Ref: 6/2023/1882/HOUSE
Date: 25/10/2023

HISTORIC BUILDINGS AND CONSERVATION ADVICE

RE: 23 Roundwood Drive Welwyn Garden City AL8 7JZ

The application is for re-routing and extension of existing footpath, resurface driveway and replace dwarf wall along front boundary.

Fig. 4. Front Elevation - Existing and Proposed

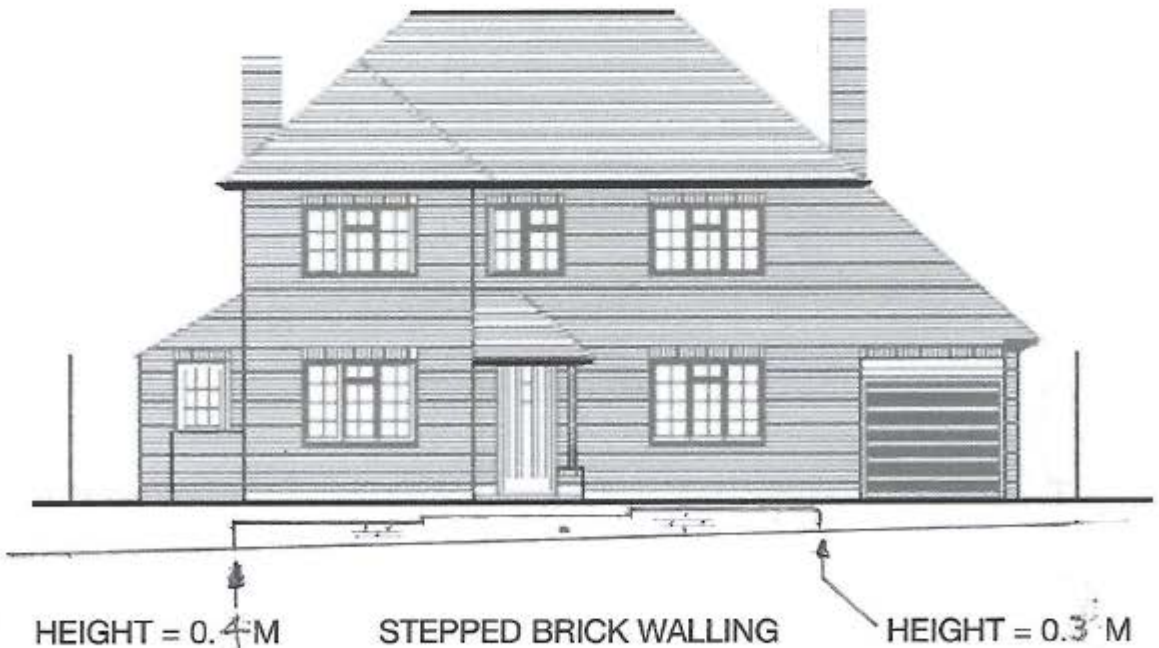
The proposed replacement brick wall would be the same height as the existing dry-stone wall. The proposed pathway would result in some minor loss of lawn, but this would not have a detrimental impact on the contribution the soft landscaping makes to the streetscene. The proposed materials are considered appropriate. The proposal would preserve the character and appearance of the conservation area in accordance with Section 72(1) of the Planning (Listed Buildings and Conservation Areas) Act 1990.
